FIVE ESTUARIES OFFSHORE WIND FARM

Appendix E6 Natural England's Benthic Ecology Advice on the Applicant's Deadline 4 Documents

Planning Inspectorate Reference EN010115

11 February 2025

DRAWING TITLE:  
 Proposed Disposal Sites for Five Estuaries

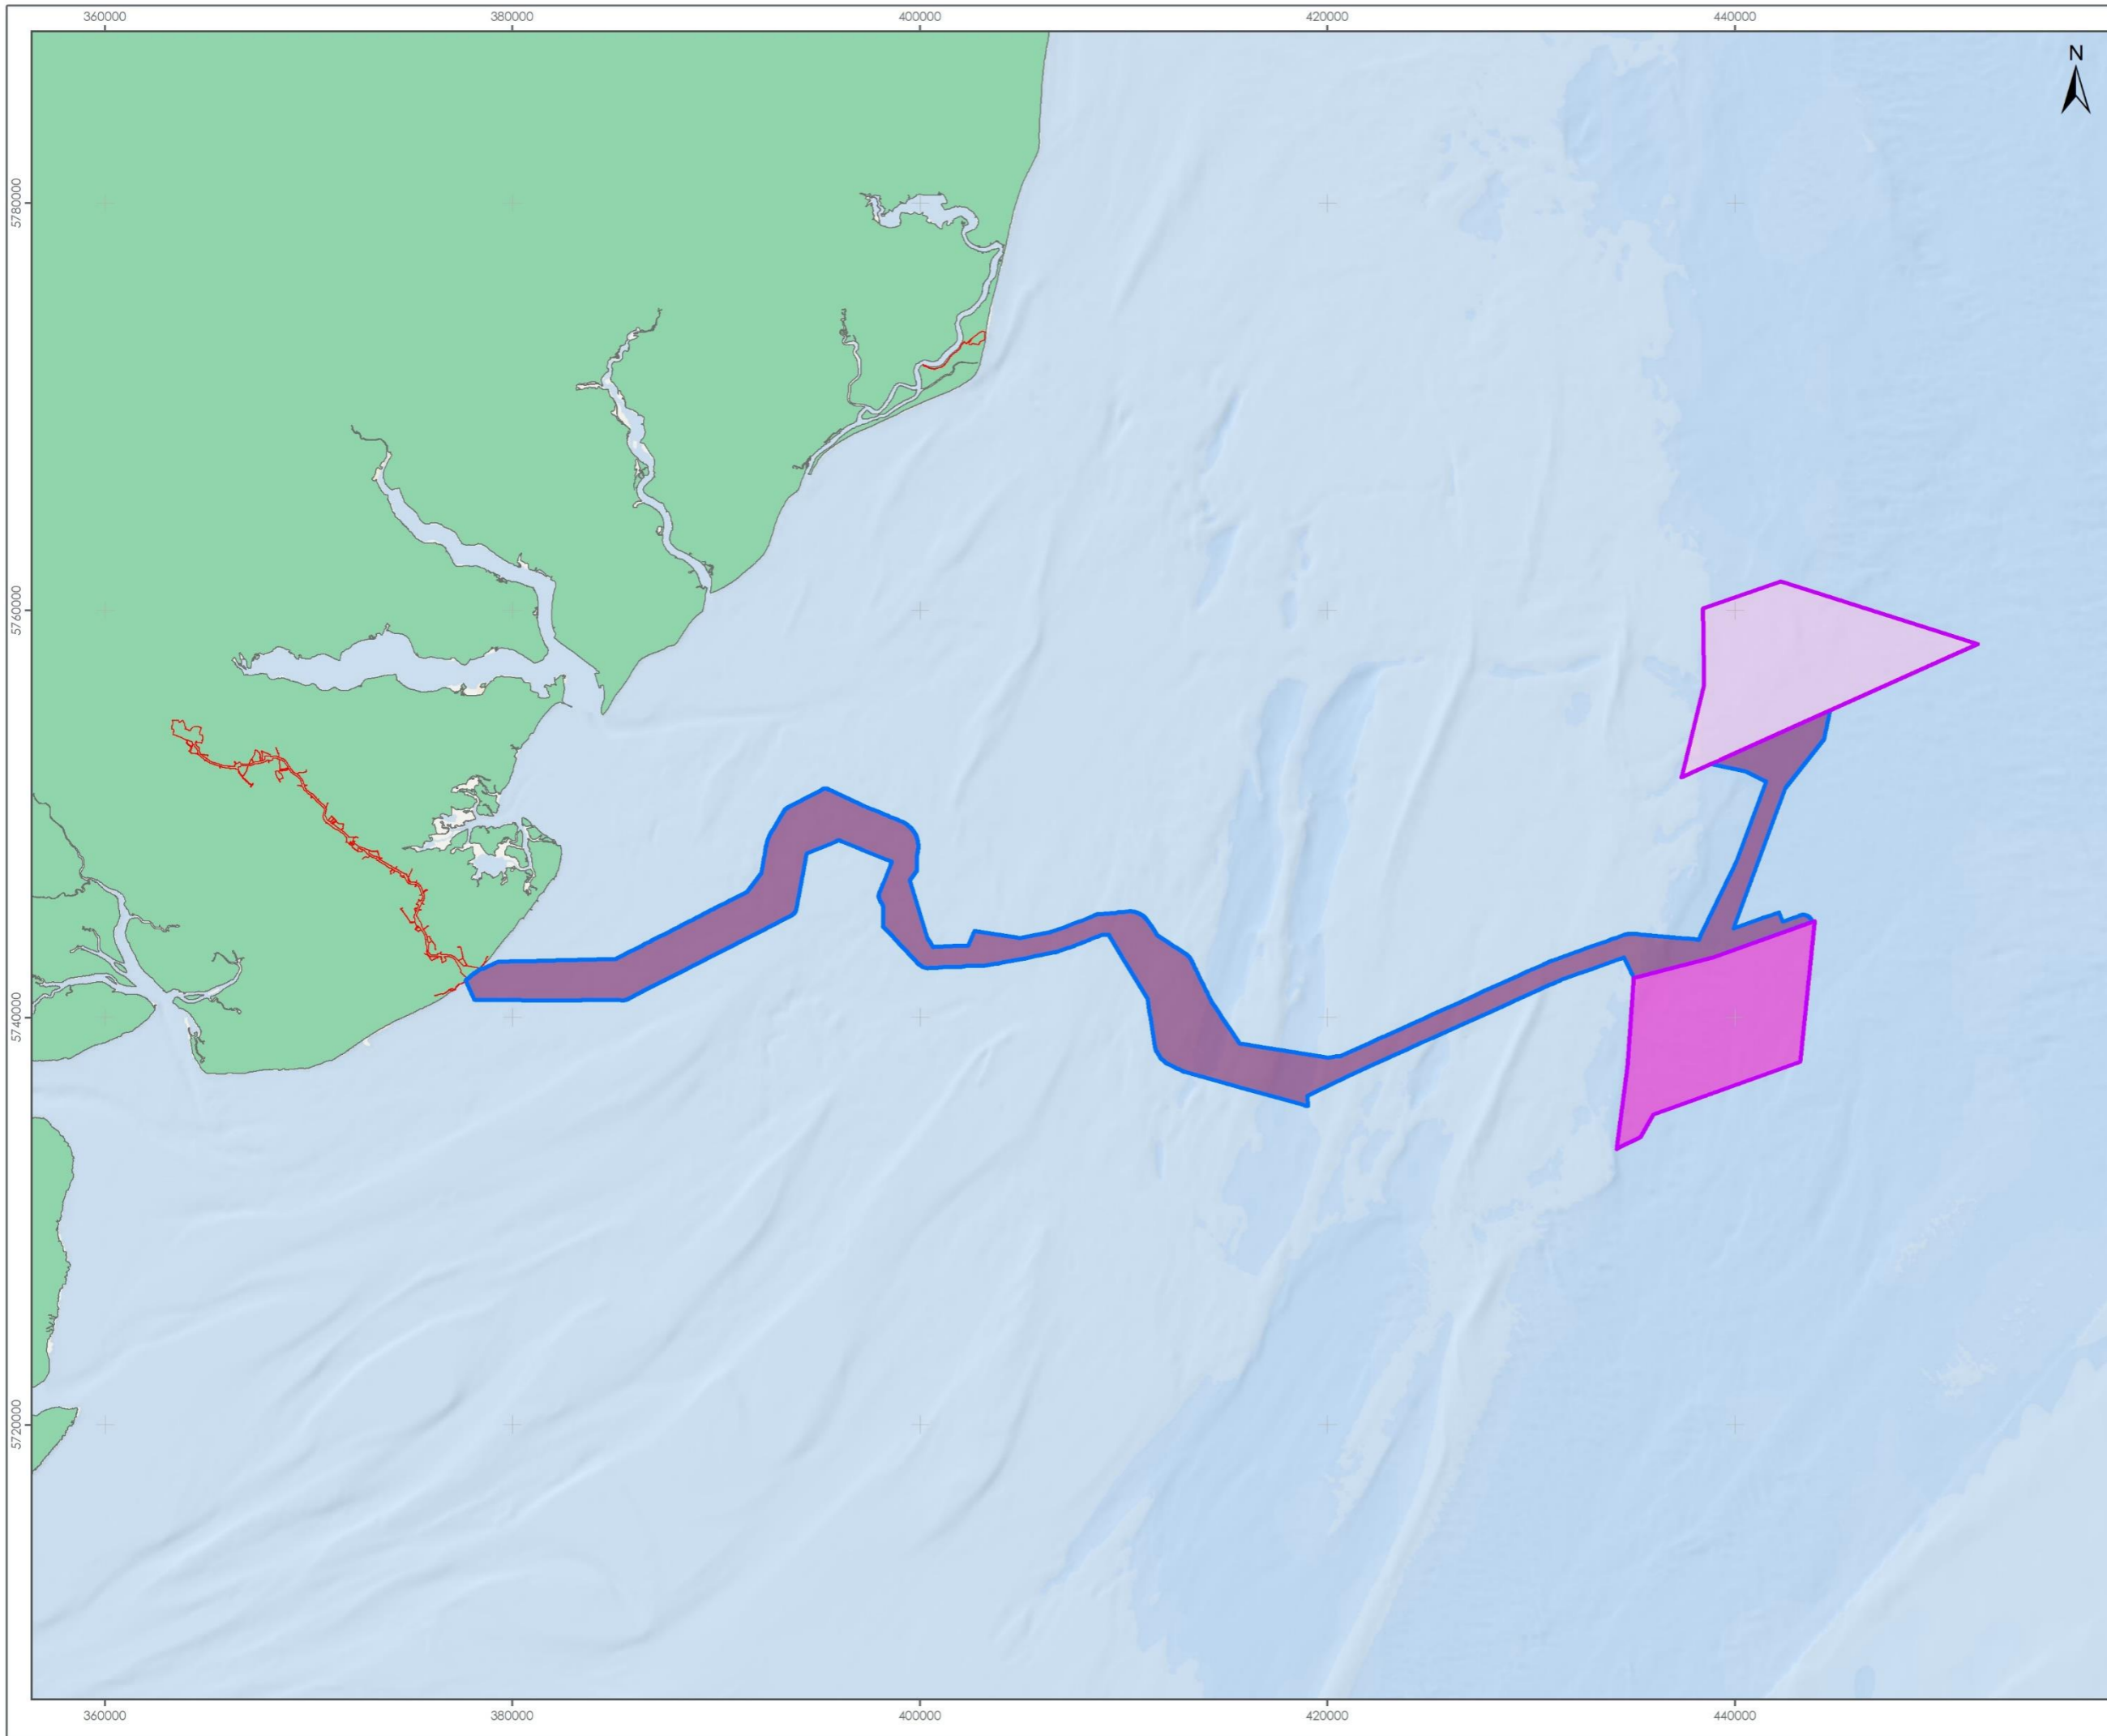
Document reviewed: [REP4-018] 9.8 Dredge Disposal Site Characterisation Report – Revision B (Tracked)			
NE Ref	Section	Key Concern and/or Update	Natural England's Advice to Resolve Issue
1	1.2.5	Natural England suggests that there are in fact 3 disposal areas namely, Array (North and South), ECC outside SAC and ECC within SAC	Natural England suggests this, and other documents are updated to ensure that there are no ambiguities of what is proposed where
2	2.1.1	The commitments for sediment disposal activities outlined within this document are not fully aligned with those listed in other documents such as the [REP4-041] 10.30 Outline Sediment Disposal Management Plan (which Natural England also advise should be updated – see other comments).	Natural England are aware that this document signposts to [REP4-041] 10.30 Outline Sediment Disposal Management Plan for specific commitments associated with sediment disposal. However, to ensure consistency and remove any ambiguity, all mitigation commitments listed within this document should be updated to align with those within [REP4-041].
